From: Contact Centre
Sent: 02 January 2024 12:06
To: dcplanning
Subject: FW: [EXTERNAL] Planning Application 23/02728/FUL

Thank you for your letter dated 14th December informing us of the planning application at Plot 5 Earnley (Meadows) Gardens, Almodington Lane, Earnley, West Sussex, PO20 7AF.

DRAWING NO. 199 / **3.001** **REVISION** 07

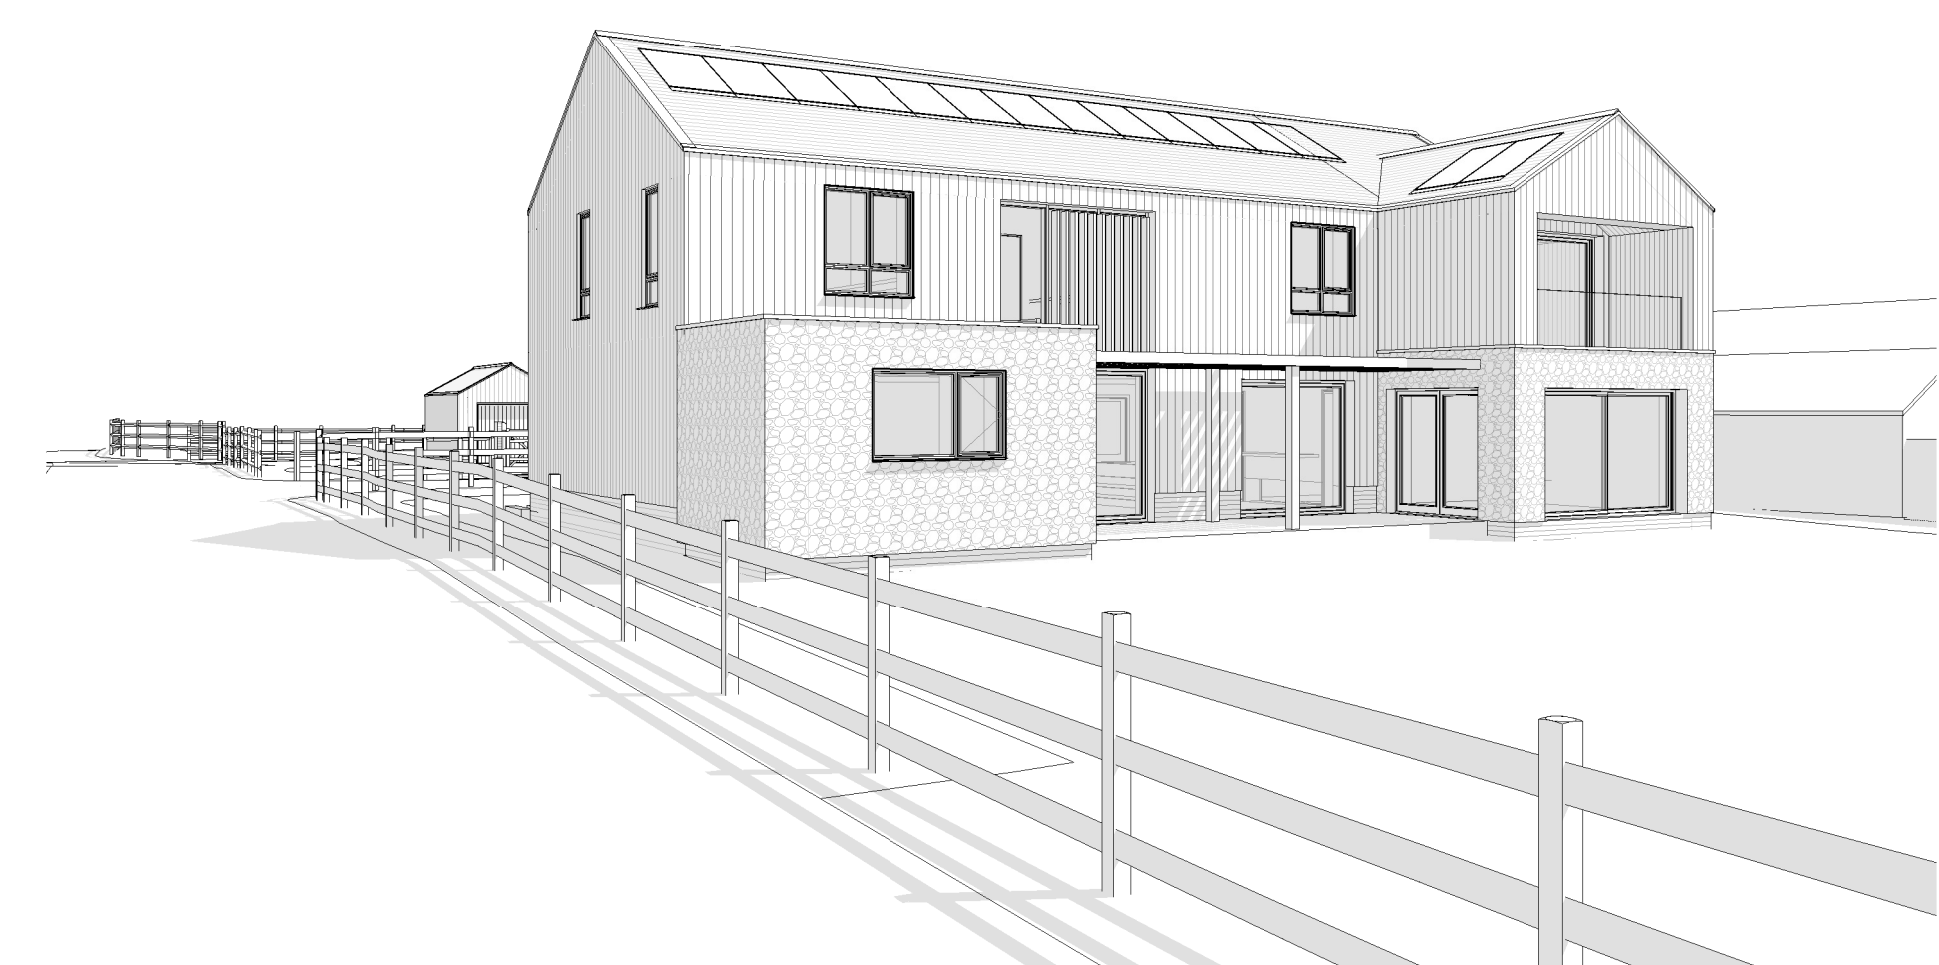
Having looked at all of the drawings we request that drawing No 199/3.001REV07 is corrected to show the correct boundary of plot No 5 which currently is incorrect. The current drawing is showing the plot edged in red to include the entrance road into the site which gives access to plots 1,2,3,4 & 5. This entrance road will be adopted by a management company of which all 5 householders in Earnley Meadows will be Directors and shareholders. Drawing No 199/3.001REV07 needs to show the entrance road edged in blue and not red.

We cannot accept the current application unless this drawing (which we believe has been inadvertently drawn incorrectly) is corrected.
